**From:** Holt, Kelly <Kelly.Holt@lancashire.gov.uk>  
**Sent:** 22 August 2018 12:08  
**To:** planning  
**Subject:** D3.2018.0637 - Time Technology Park

### D3.2018.0637 – Time Technology Park, Blackburn Road, Simonstone Proposed new business unit

SITE PLAN 1:250

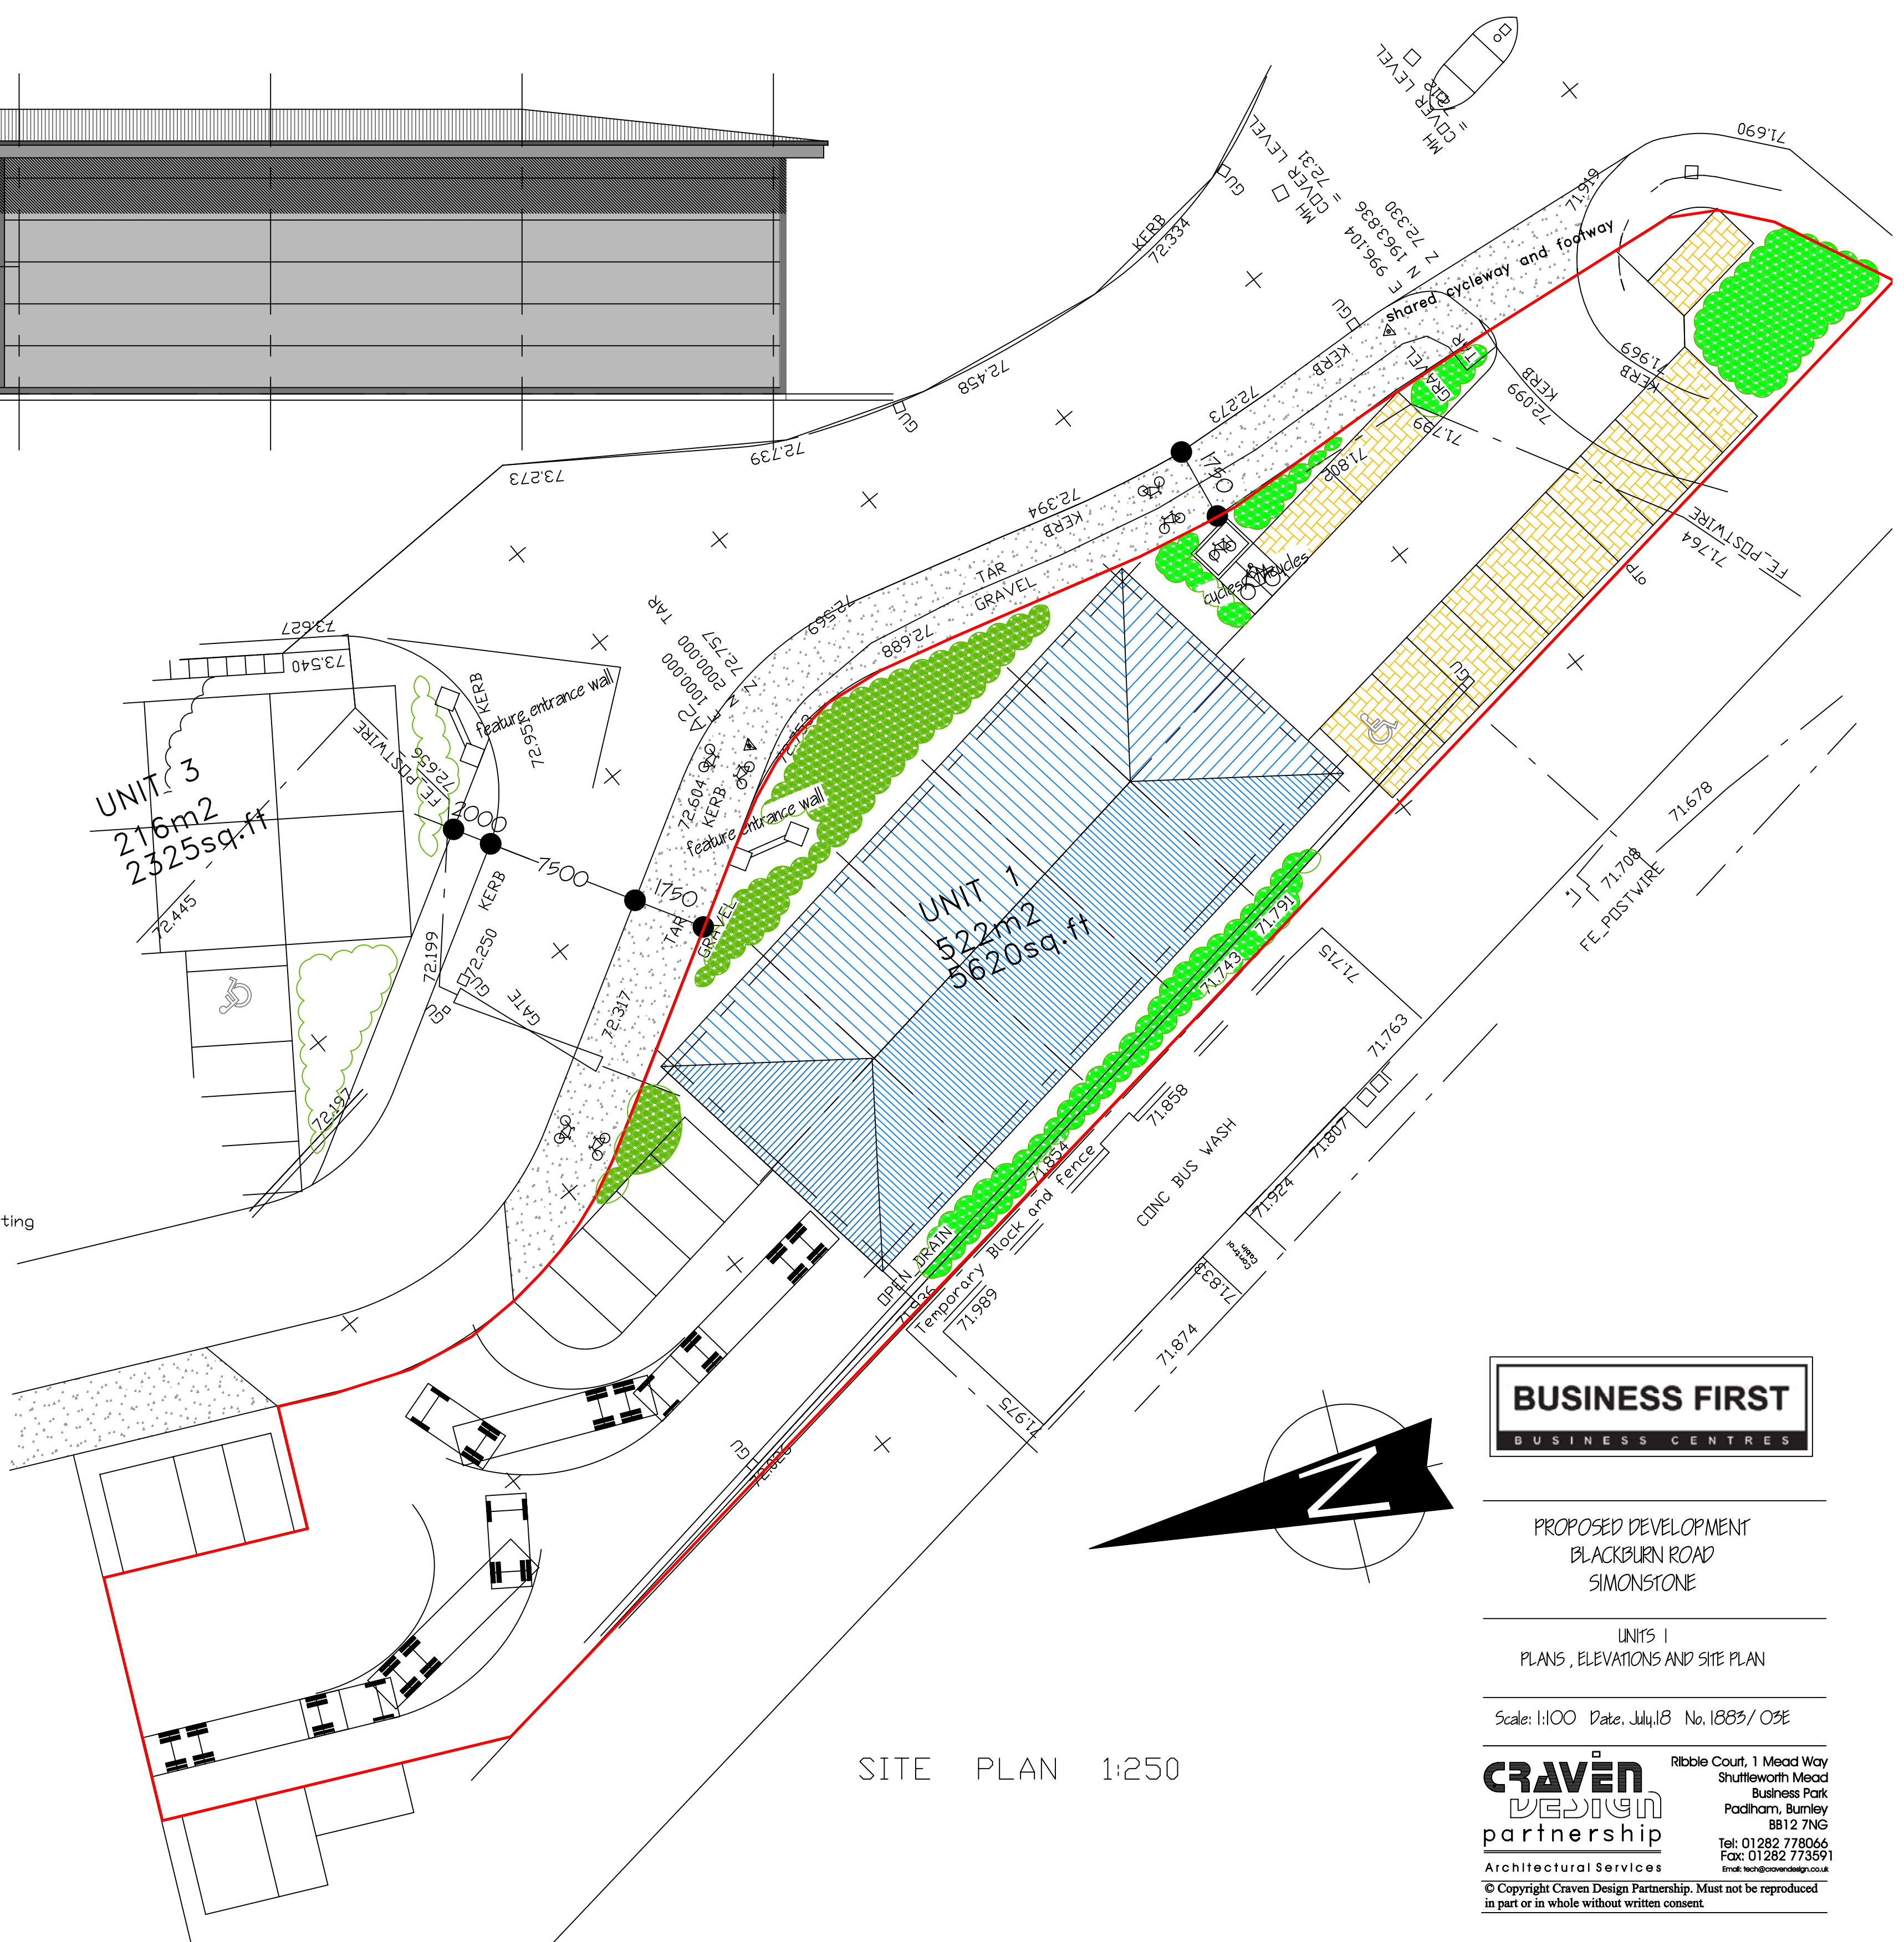
It will be necessary to submit a swept path analysis to show that a HGV or articulated vehicle (whichever is the largest that this business will generate) can enter in forward gear, reverse turn and exit onto the estate road in forward gear.

A ratio of 1:30 has been applied to calculate the car parking provision and this is applicable to a B1 office use. In this case I would suggest that a lower ratio of 1:45 for B2 general manufacturing should be used which equates to 12 spaces. There is no objection to the proposed level of car parking at the site however it may be necessary to remove the 4 car parking spaces from the service yard to provide an increased service yard area for the maneuvering of large vehicles. The swept path analysis will dictate this.

SITE PLAN 1:250

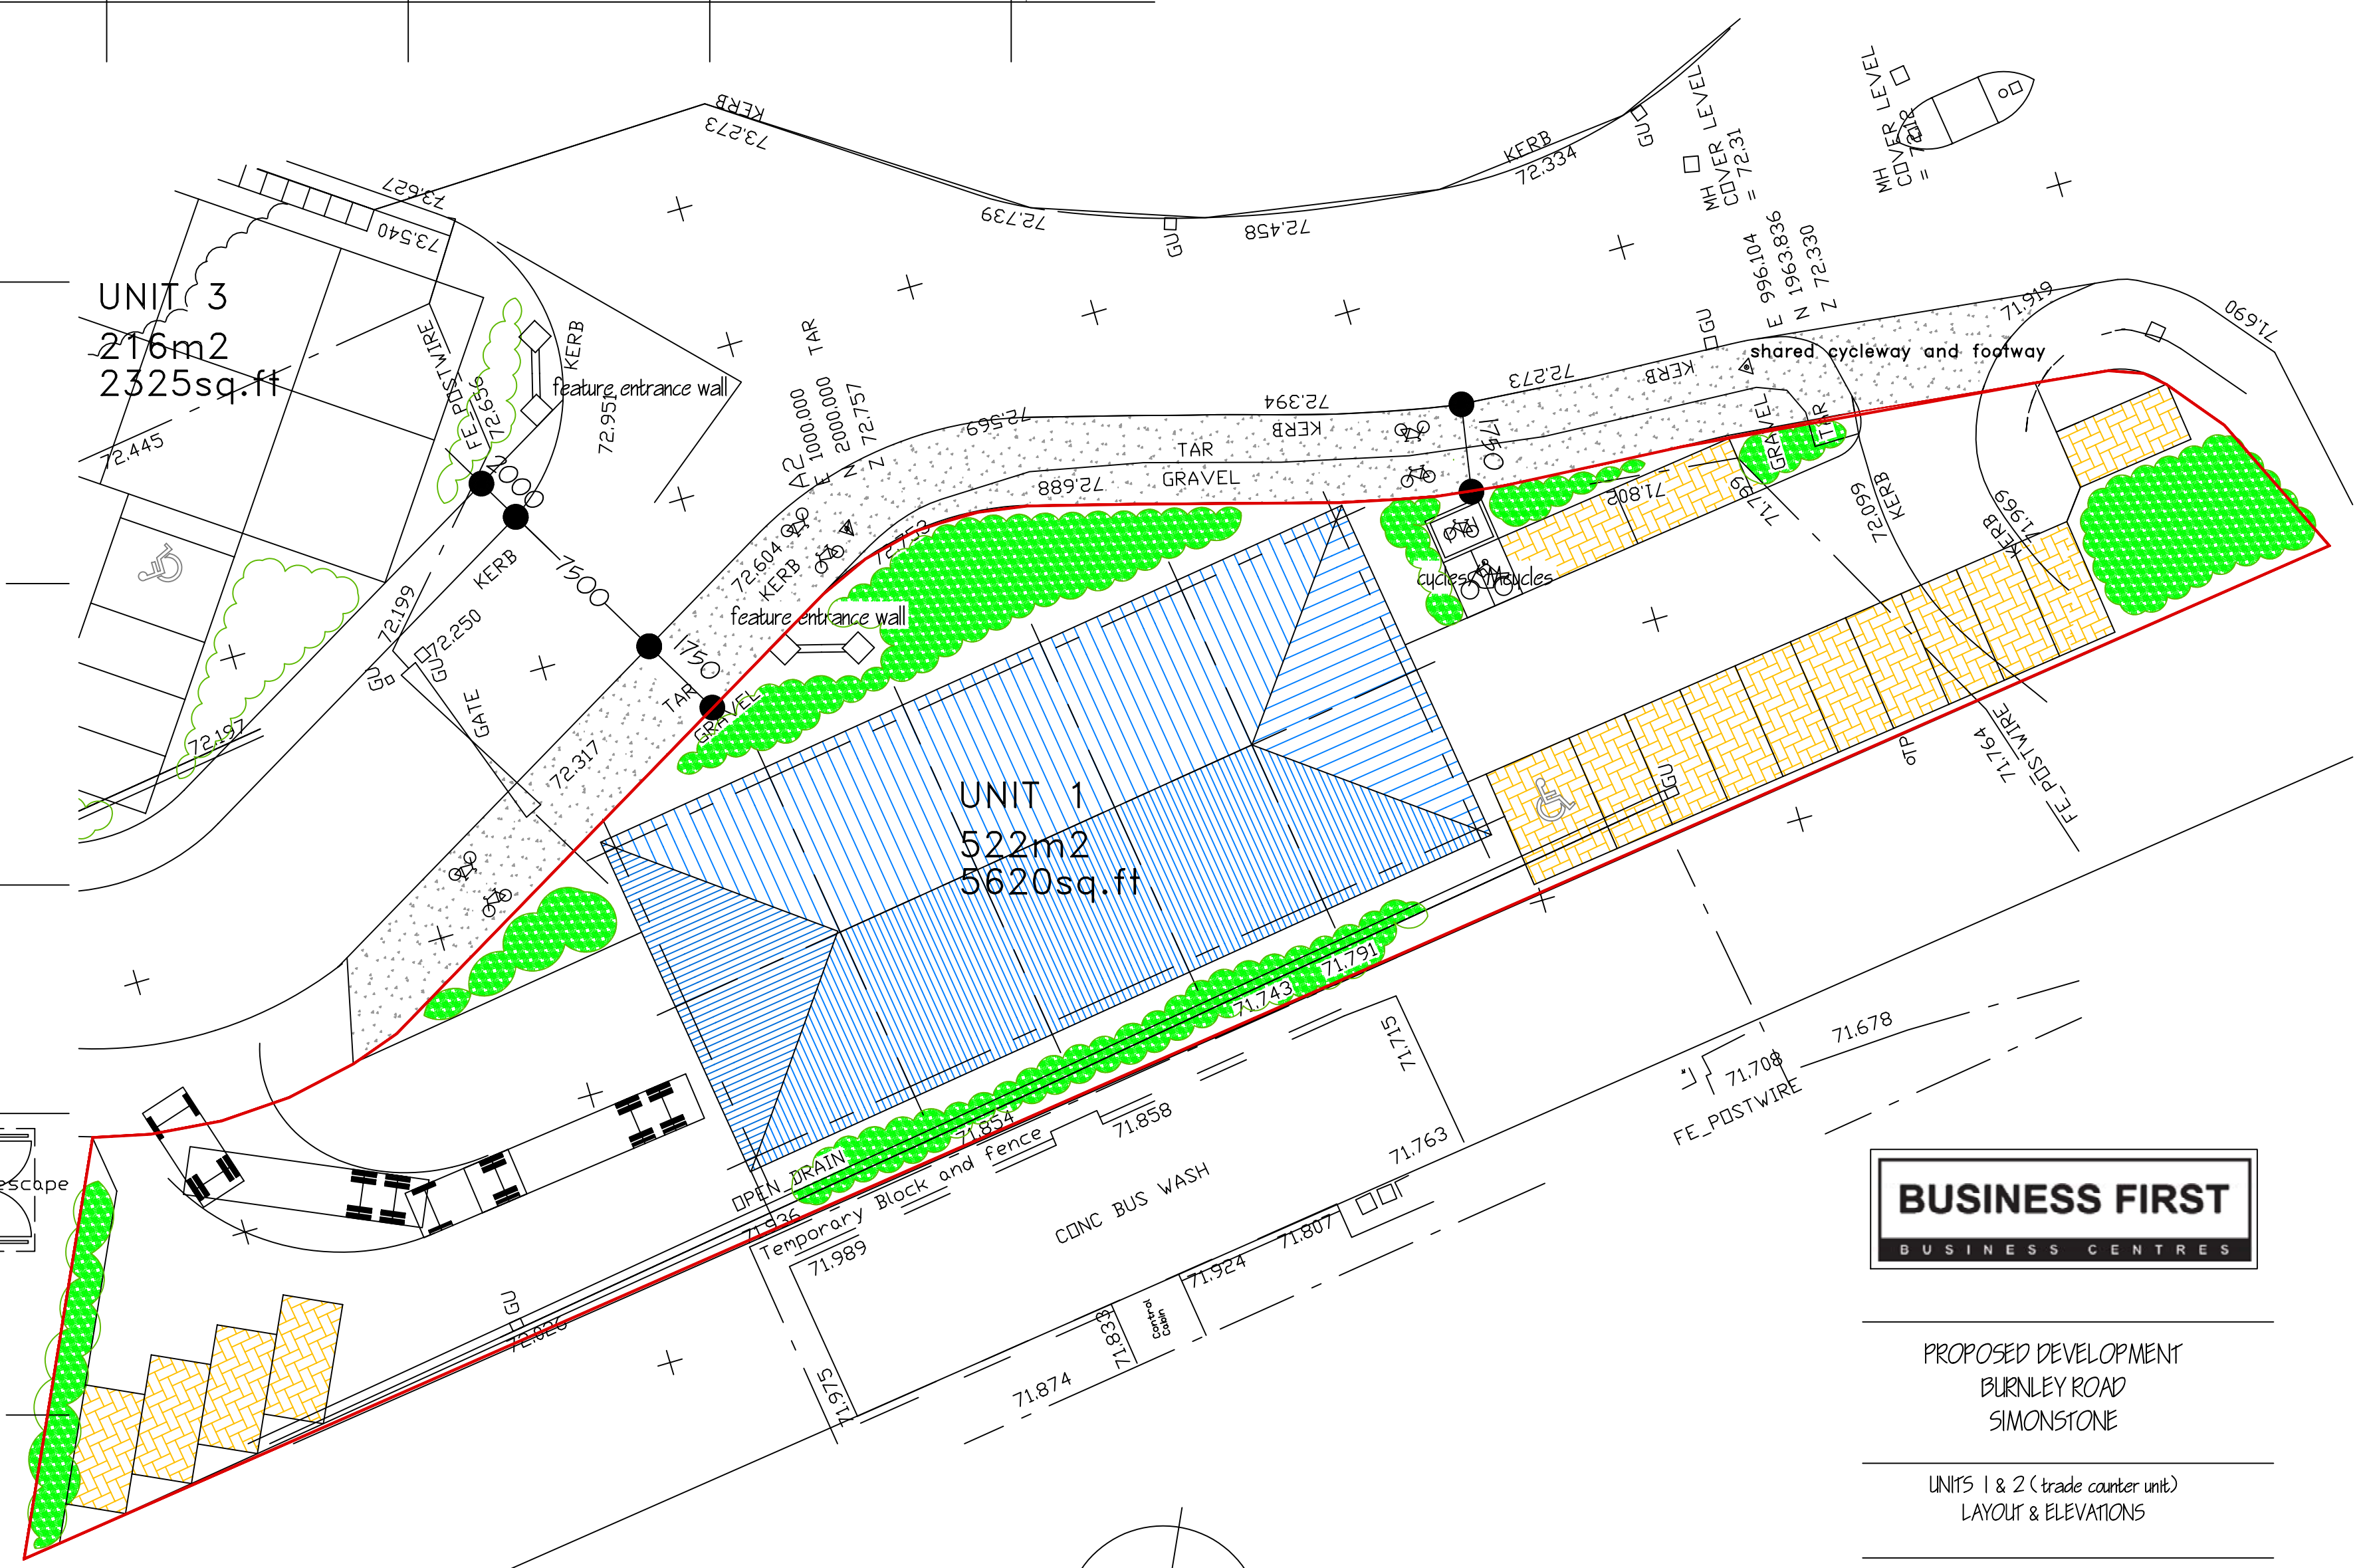
This application seeks to replace the approved Units 1 & 2 (724sqm combined B1 office use with 24 car parking spaces) with a single unit (522sqm B2/8 use with 17 car parking spaces and a small service yard).
